Dean Moor Solar Farm – Applicant response to S51 Advice

Application Ref: EN010155

- Legend**
- Order Limits
 - Proposed alteration of street
 - AS/1 Alteration of street location reference (Schedule 5)
 - Existing access to be improved
 - A/1 Means of access location reference (Schedule 7)

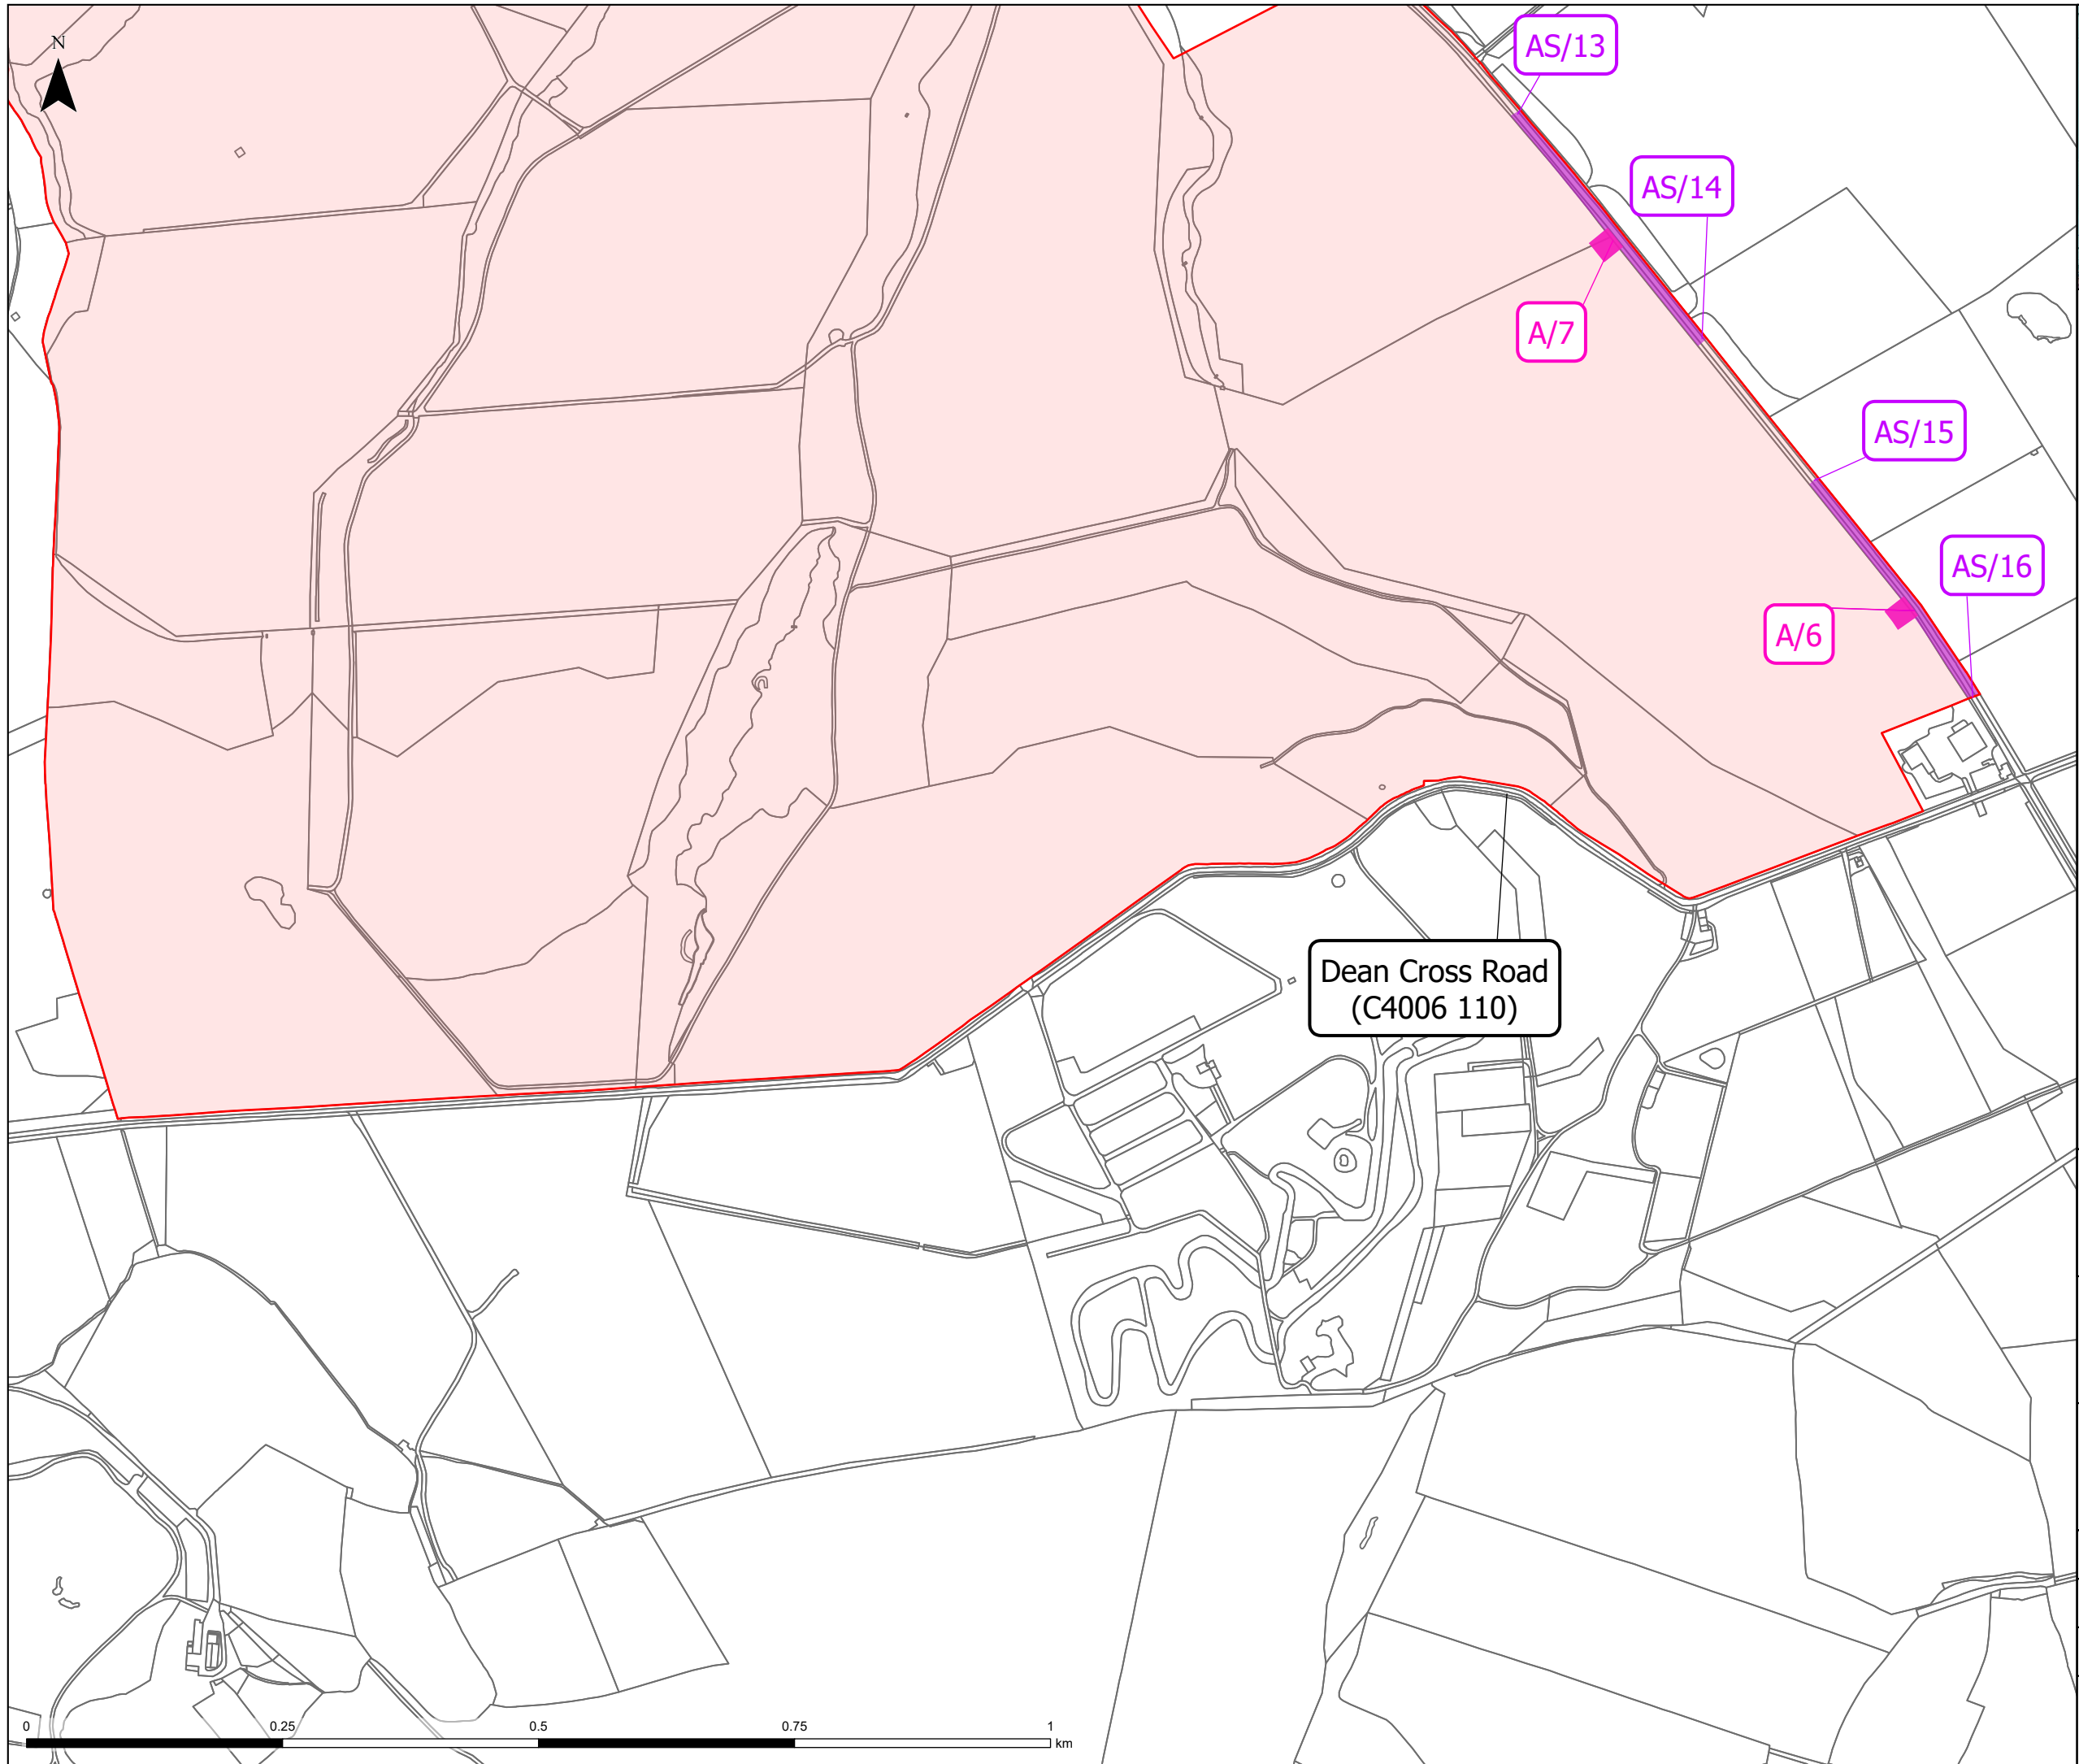
3	Streets and Access Plans (Doc 2.4)	The plans do not have any road names as identified in the dDCO.		The Street Works and Access Plans [APP-006] have been updated accordingly and are included with this response.
4	Traffic Regulation Measures Plan (Doc 2.5)	The plan does not have any road names as identified in the dDCO. Schedule 6 of the dDCO states points TSC/1 and TSC/2 hatched yellow on the plan, but the colour on the plan is orange.		The Traffic Regulation Measures Plan has been updated accordingly. The changes include: <ul style="list-style-type: none"> ▪ Adding the road names identified in the dDCO; and ▪ Changing the colour on the plan to yellow so that it reflects the wording in Schedule 6 of the dDCO. The updated plan is included with this response, this would supersede the originally submitted version of the Plan [APP-009] .
5	Consultation report (Doc 5.1)	The Applicant has provided a list of persons consulted under s42(1)(a) on 9 March 2024 at Appendix 5.1, however elsewhere in Appendix 4.7 the Applicant refers to a definitive list of consultees who were actively consulted in Appendix 3.9. We were unable to locate Appendix 3.9 within the submitted application documents. If this appendix is missing, we request this to be submitted before the Relevant Representation period opens.		Please note that reference to Appendix 3.9 is incorrect and that all stakeholders consulted under s42(1)(a) are captured in Appendix 5.1. The Consultation Report has been updated to reflect this. This was issued to the Planning Inspectorate on 07/05/2025 [AS-001] .

Environmental Statement: Chapter 8 – Figure 8.1 Statutory Designated Sites

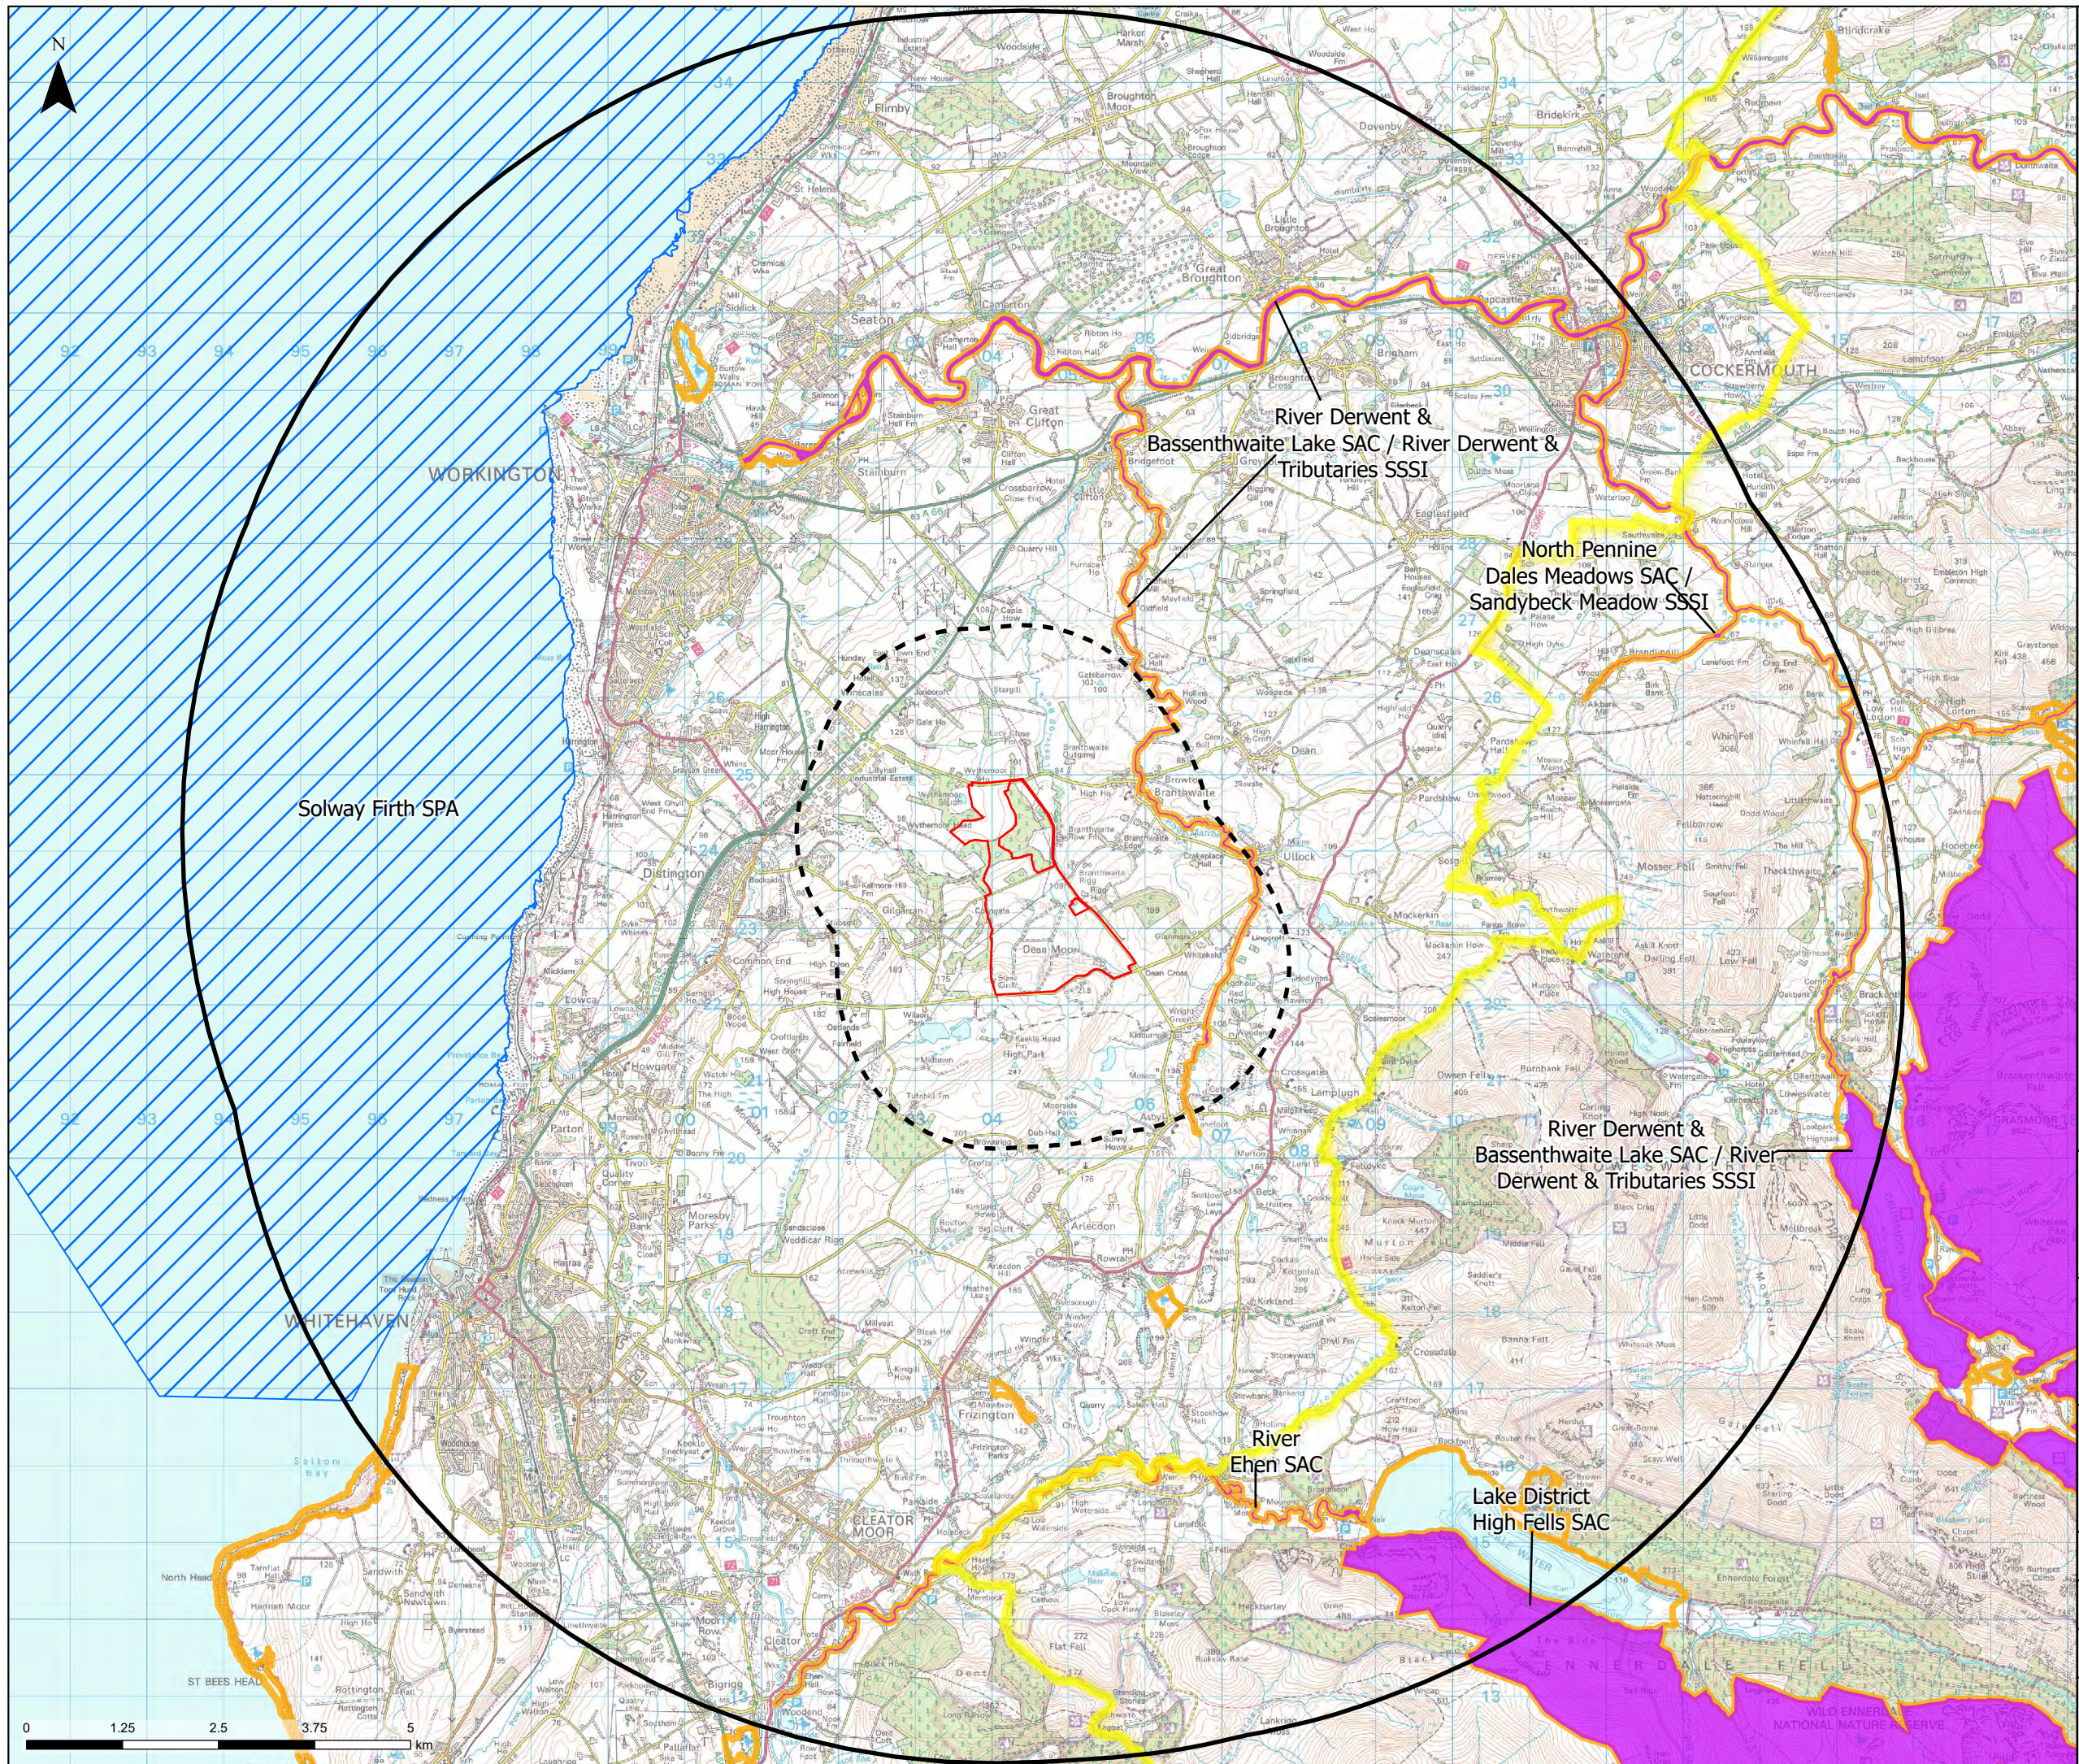
8	ES Figure 8.1 – Statutory Designated Sites (Doc 6.1)	The applicant should ensure figures are clear as possible for the end user. Colour choices for the legend in ES Figure 8.1 are not easily identified and a substantial bleed has been included for the Lake District National Park making the exact border location unclear.		The Applicant has made the necessary updates to this Figure which is provided with this s51 response. This supersedes the originally submitted version of the Statement [APP-089] .
9	Non-Technical Summary (Doc 6.4)	Several of the Figures within the NTS do not match the corresponding ES Chapter Figures (Doc 6.2). This is confusing and potentially misleading when cross-referencing material.		<p>The NTS is an independent document, and the Figures are labelled independently in a way that is logical and consistent with when they appear in the NTS.</p> <p>The Applicant is keen to avoid changes, as renumbering would be confusing within the NTS.</p>
